From: Graeme Thorpe
Sent: 24 January 2012 10:16
To: Helen Booth
Subject: FW: Consultation on planning application 3/2011/0995 Oakmount Farm, Ribchester Road, Clayton le Dale

From: Hornby, Mark [mailto:Mark.Hornby@lancashire.gov.uk]
Sent: 23 January 2012 15:11
To: Graeme Thorpe
Subject: FW: Consultation on planning application 3/2011/0995 Oakmount Farm, Ribchester Road, Clayton le Dale

sheet: existing and proposed site plan

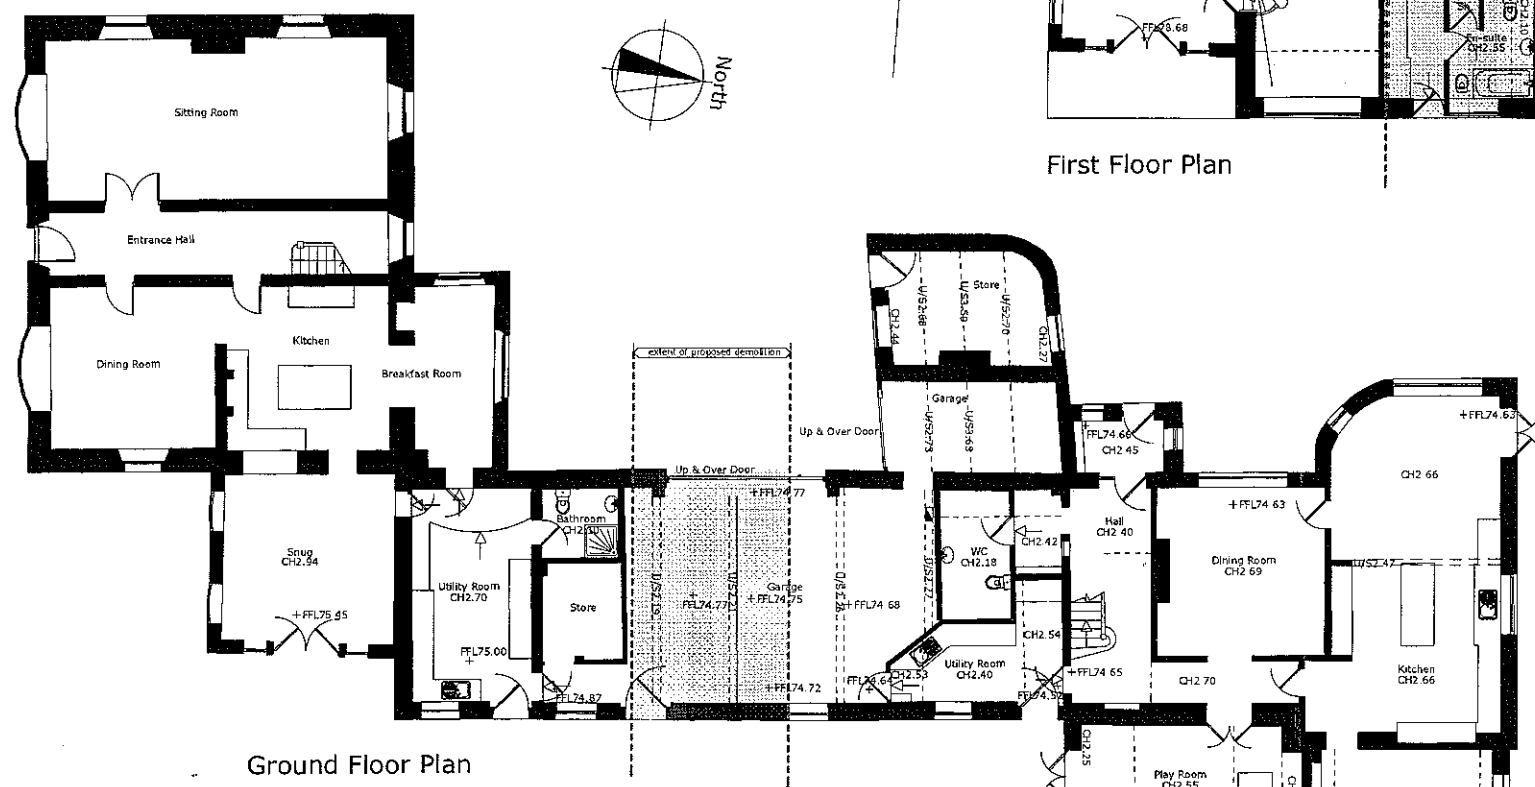
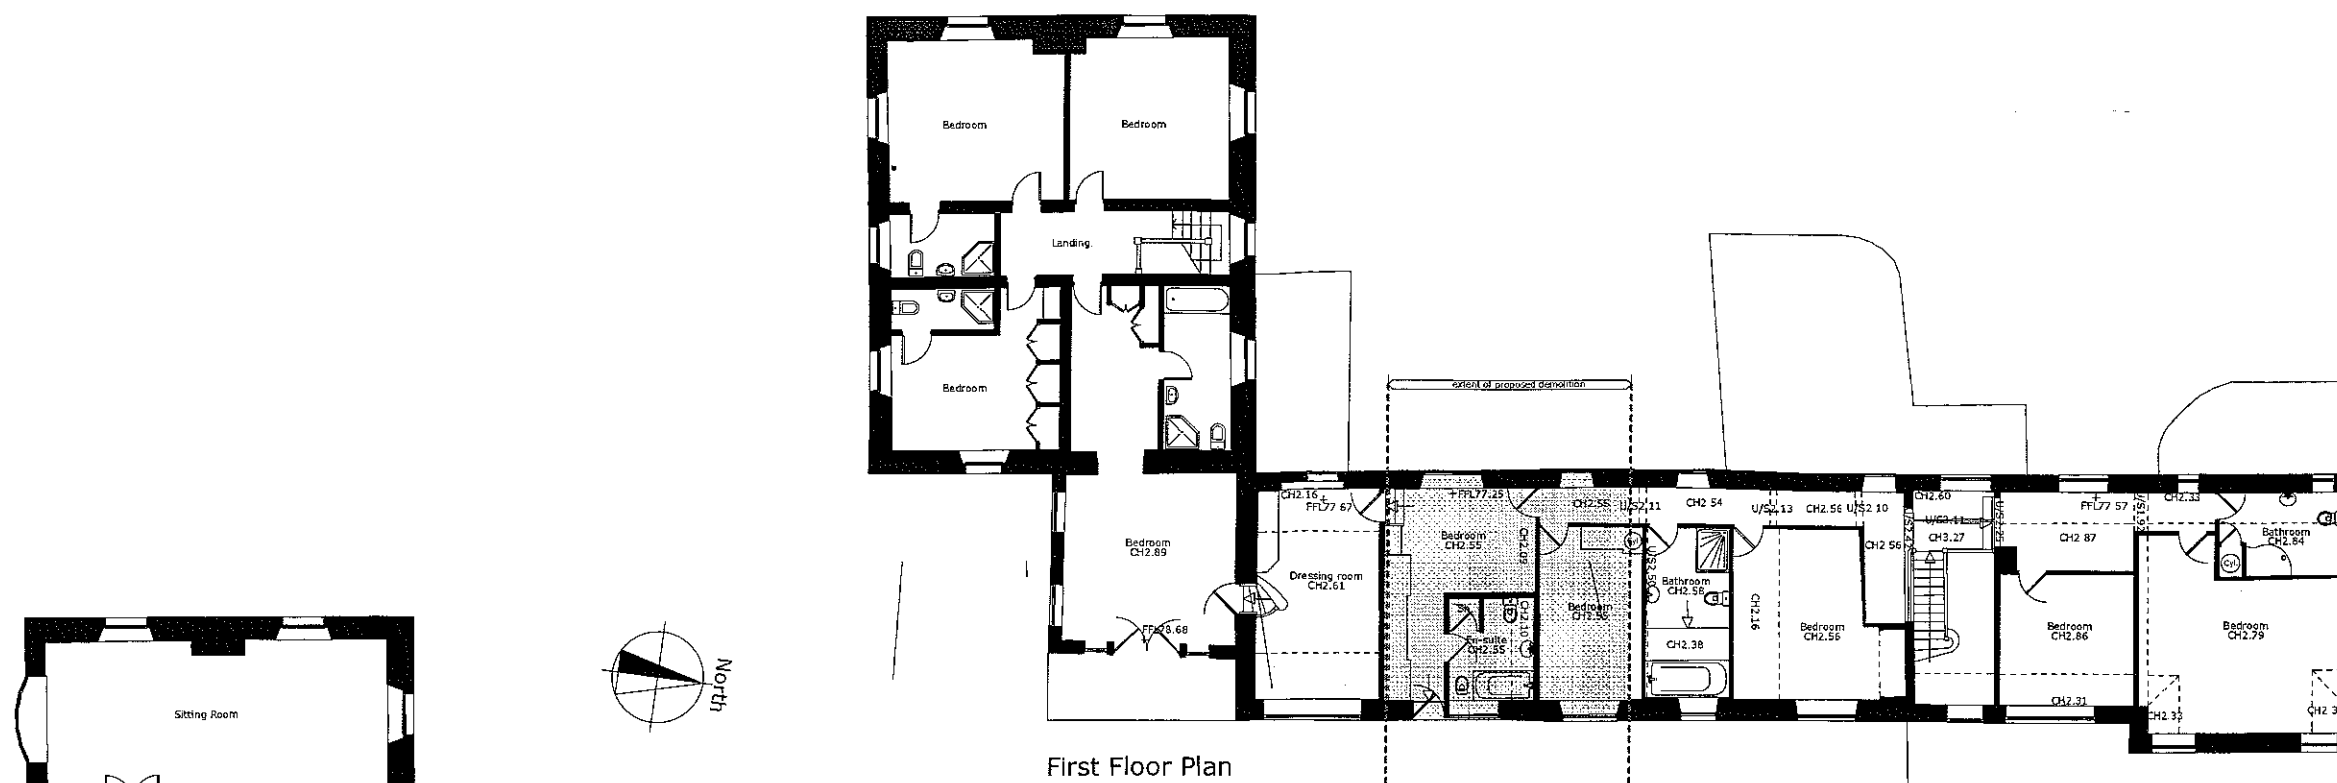
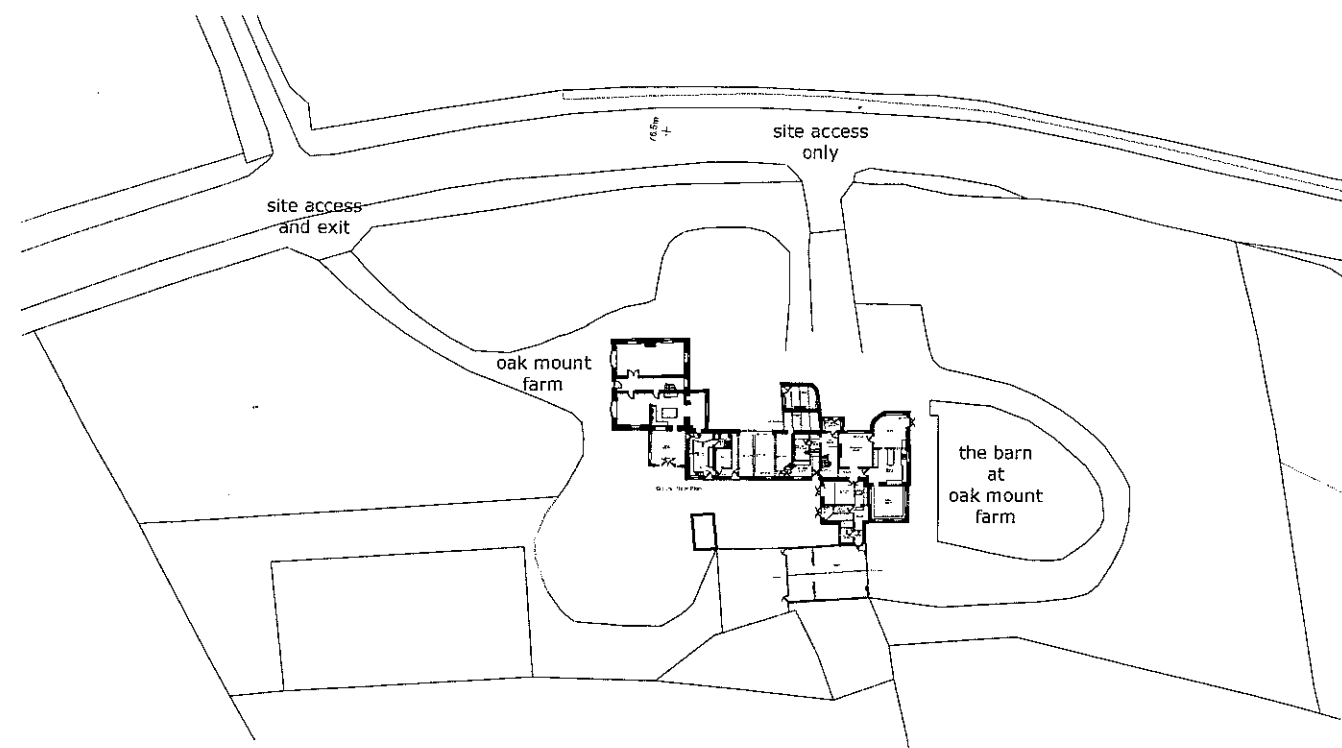
I have no objection to this proposal provided that the northern access point remains for the use of vehicles entering the site only

I note that the intention is to widen the northern access point, therefore please add the following note to any permission granted:

Note: This consent requires the construction, improvement or alteration of an access to the public highway. Under the Highways Act 1980 Section 184 the County Council as Highway Authority must specify the works to be carried out. Only the Highway Authority or a contractor approved by the Highway Authority can carry out these works and therefore before any access works can start you must contact the Environment Directorate for further information, details below:
